REQUEST

Current Zoning: N1-A (neighborhood 1-A)
Proposed Zoning: N2-A(CD) (neighborhood 2-A, conditional)

Approximately 14.85 acres located on the northeast side of Paw Creek Road, east of Little Rock Road.

The petition proposes the development of up to 127 duplex, triplex, and quadruplex dwellings. The property is currently the site of 1 single-family dwelling.

RZ-2

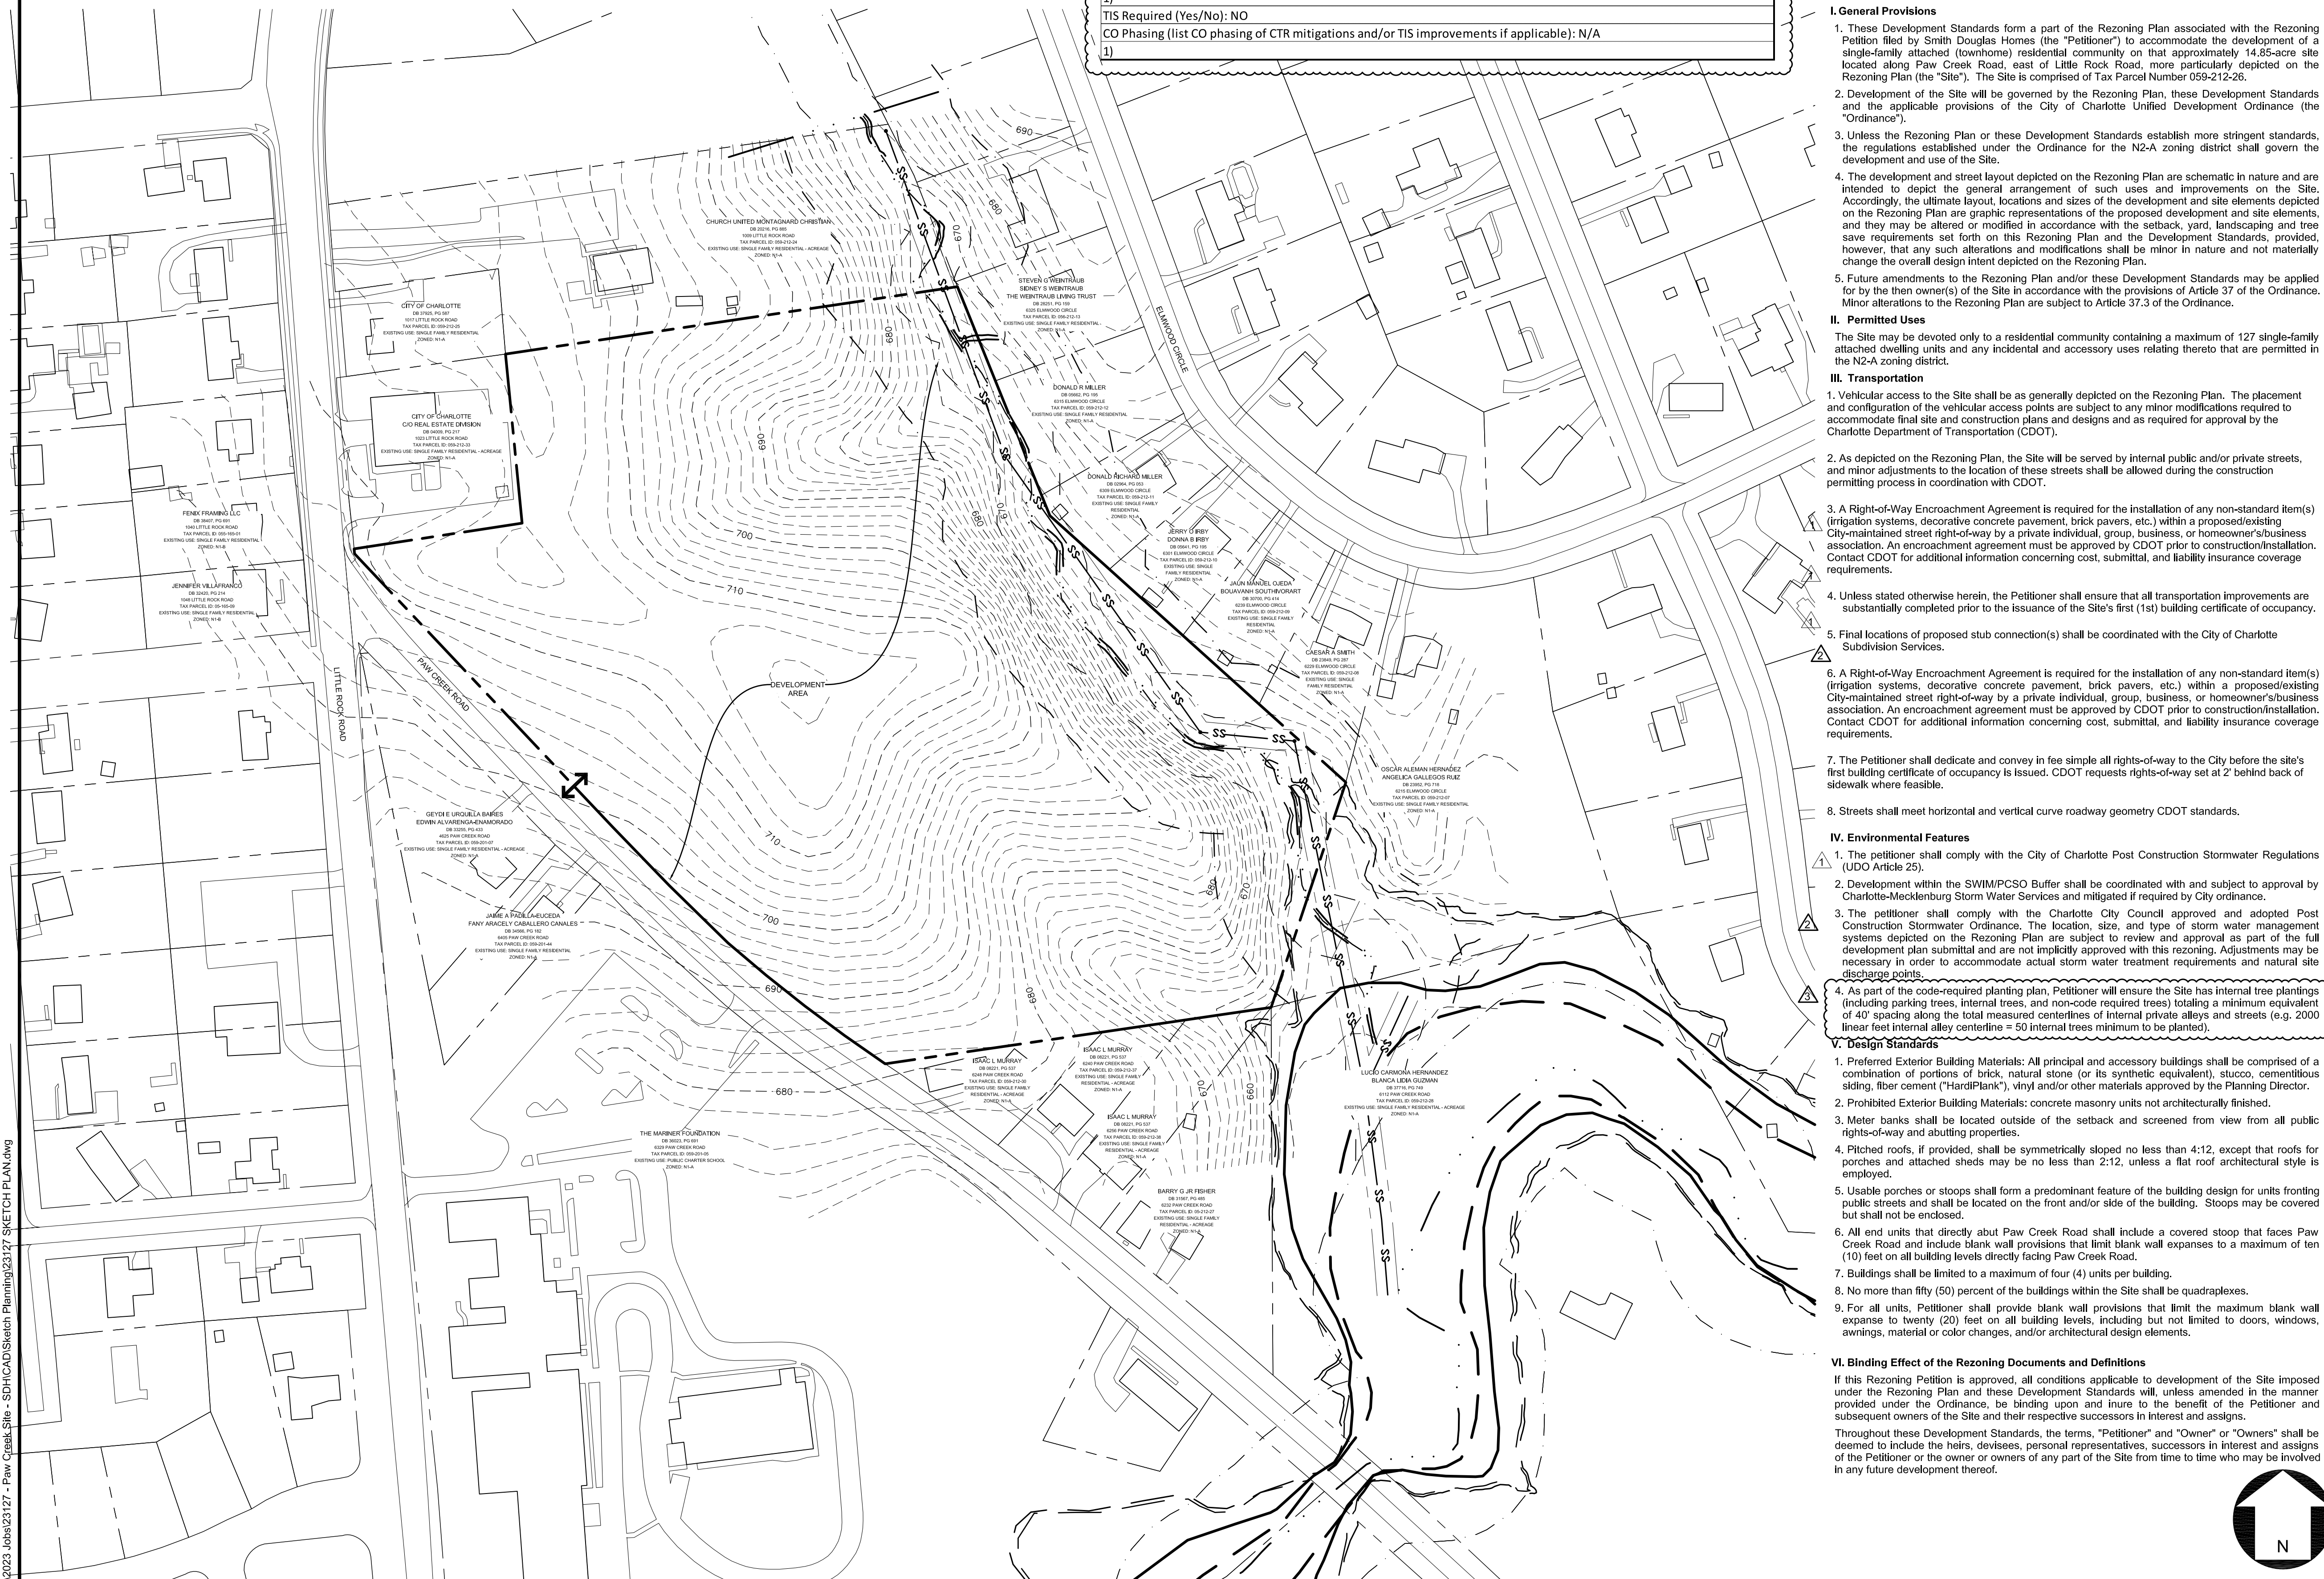
- The petition is located at the intersection of Little Rock Road, a State-maintained major arterial, and Paw Creek Road, a City-maintained minor arterial. Based on the 917 daily trips, the petitioner will be required to satisfy Tier 1 Multimodal assessment (3 points). Site plan and/or conditional note revisions are needed including completion of the CTR and addition of those commitments to the conditional notes.

5. Comprehensive Transportation Review (CTR). The petition's zoning falls within the low intensity development which based on the 917 daily trips will trigger Tier 1 (3 mitigation points) for multimodal assessment. The petitioner shall review and assess the publicly accessible pedestrian network within ¼ mile walking distance of the site to identify multimodal infrastructure to meet the Tier 1 (3 mitigation points) for multimodal assessment.

RZ-2

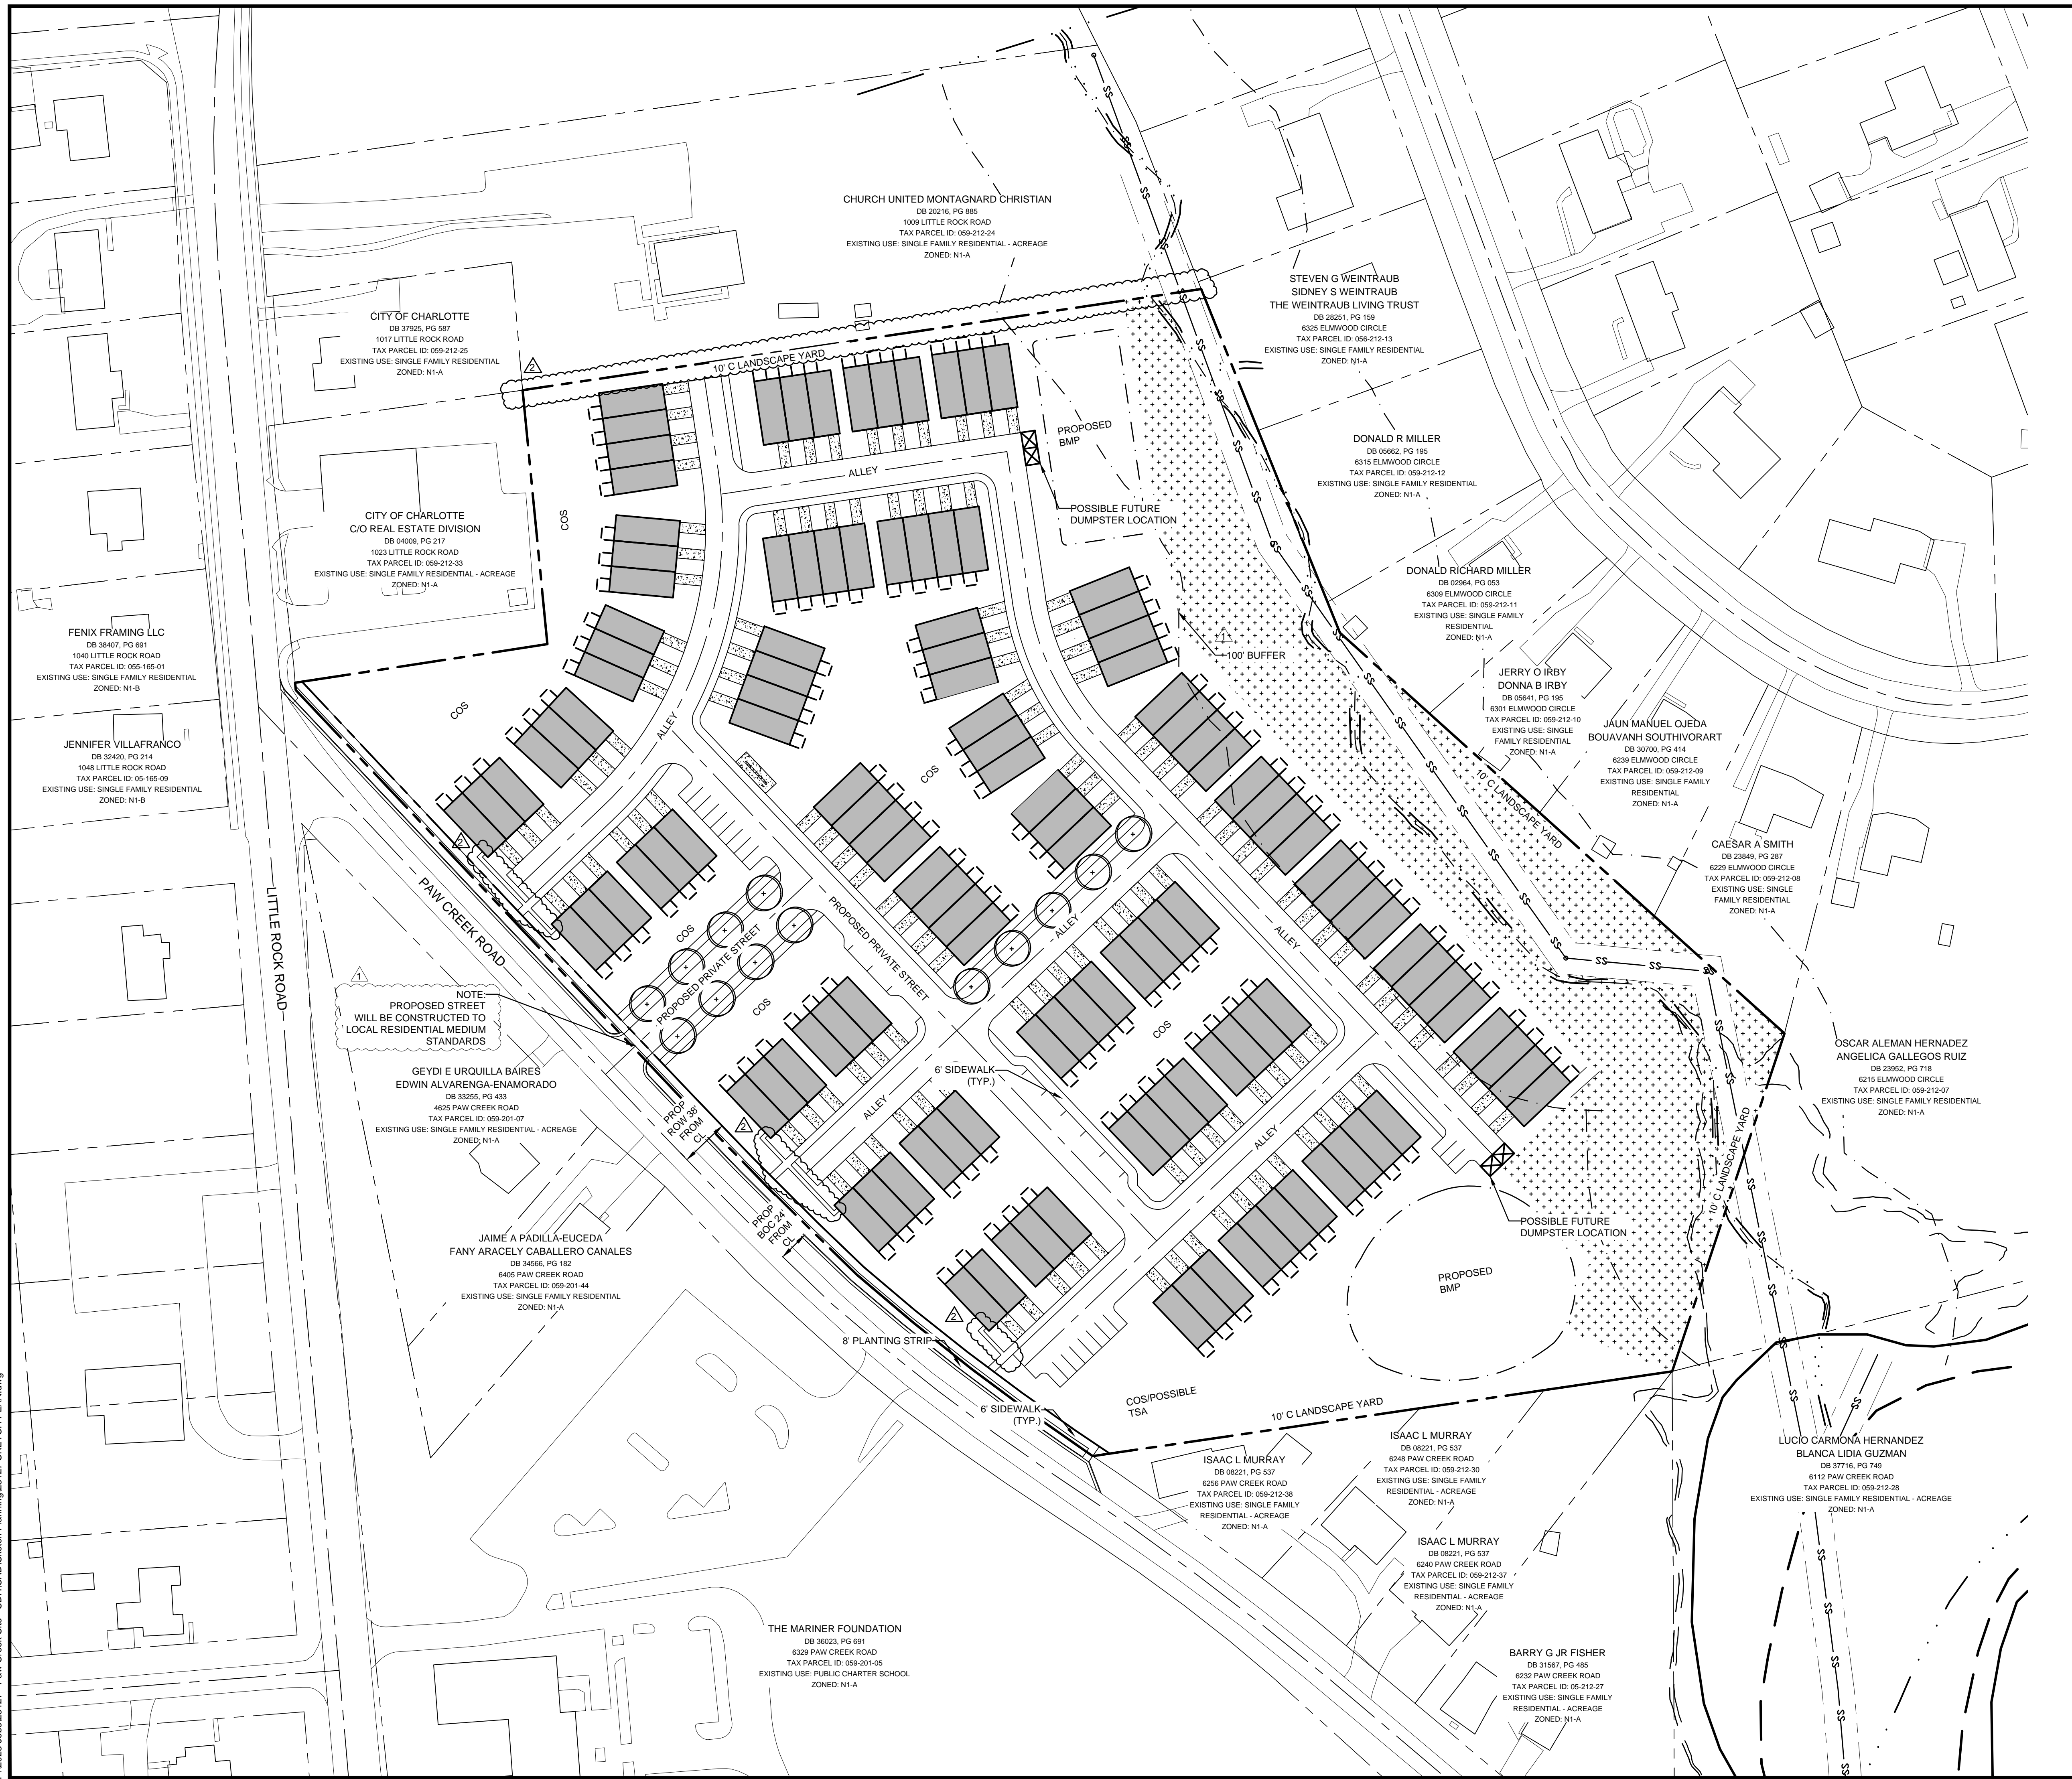
- In the Neighborhood 1 zoning districts, dwelling must be built on individual lots fronting public streets and the *2040 Comprehensive Plan* calls for the character of developments in Neighborhood 1 Place Type to consist of front lawns, landscaped yards, and tree-lined streets. The proposed plan consists of a network of private alleys with front-loaded driveways providing limited yards and few street trees.

1. ~~Provide a maximum number of units per building and a commitment to a minimum ratio of duplex, triplex, quadruplex, and potentially single family dwelling unit types.~~ Addressed
2. ~~Provide a landscape yard along the northern property boundary adjacent to the abutting church use and remove and/or relocate the dumpsters from this location adjacent to the property line.~~ Addressed
3. Consider reorienting the buildings adjacent to Paw Creek Road so that units front on the public street and parking is rear alley loaded.
4. Consider providing more streets built to public standards rather than alleys being the predominant road type.
5. Consider adding additional street trees throughout the project or better show where proposed street trees will be incorporated if not reflected on the site plan currently.
